Lead Local Flood Authority

RE: LU/72/25/OUT - Paynters Croft, Burndell Road, Arundel, BN18 0HR

We **object** to this planning application in the absence of an acceptable Flood Risk Assessment (FRA) and Drainage Strategy relating to:

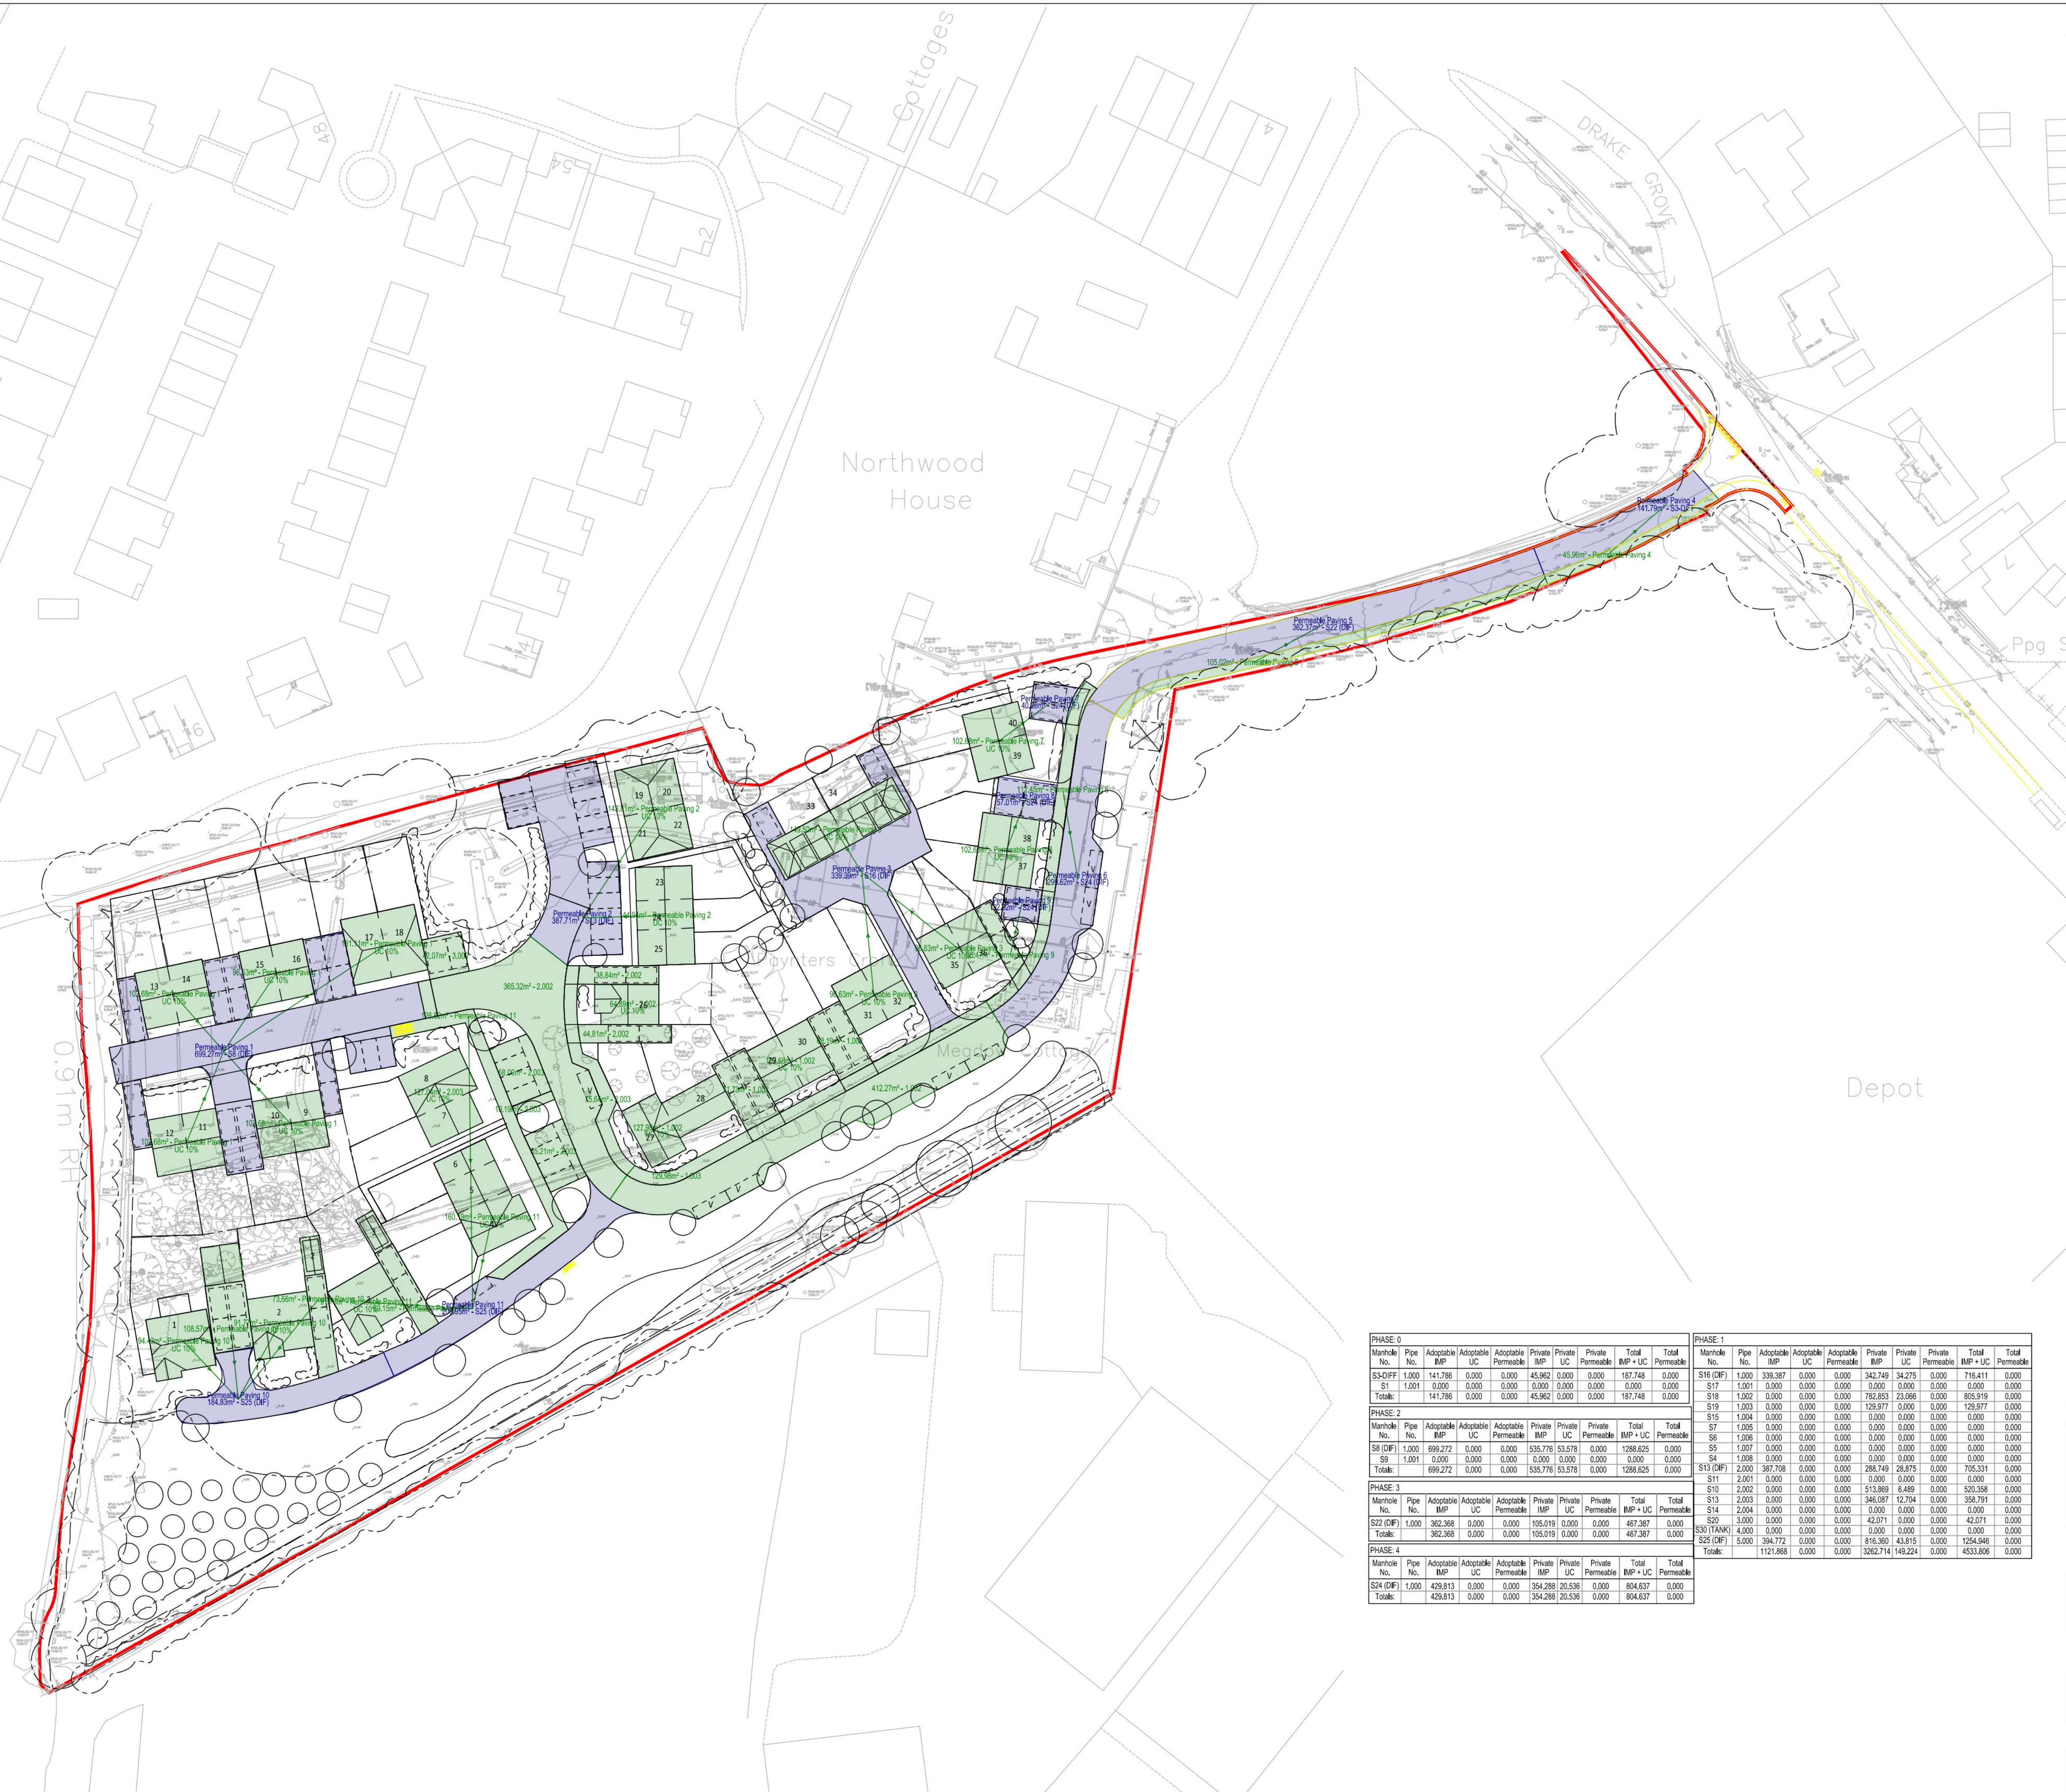
2. Updated calculations for the entire site are required to ensure the proposed surface water drainage network can appropriately drain the development.

1. It is unclear whether urban creep has been used within the calculations. This shall be selected in line with the National Standards for SuDS.
2. Further details of the maintenance and management of SuDS features is required. **This can be conditioned, although we recommend early consideration of management and maintenance.**

3. Updated FRA and Drainage Strategy presented for consideration with appropriate plans at sufficient detail design status to establish principle.
4. Revised Calculations to current standards (eg FEH2022, CV=1 both Summer and Winter, Climate Change 45%), ensure storage quoted can be achieved at a range of rainfall event scenarios.
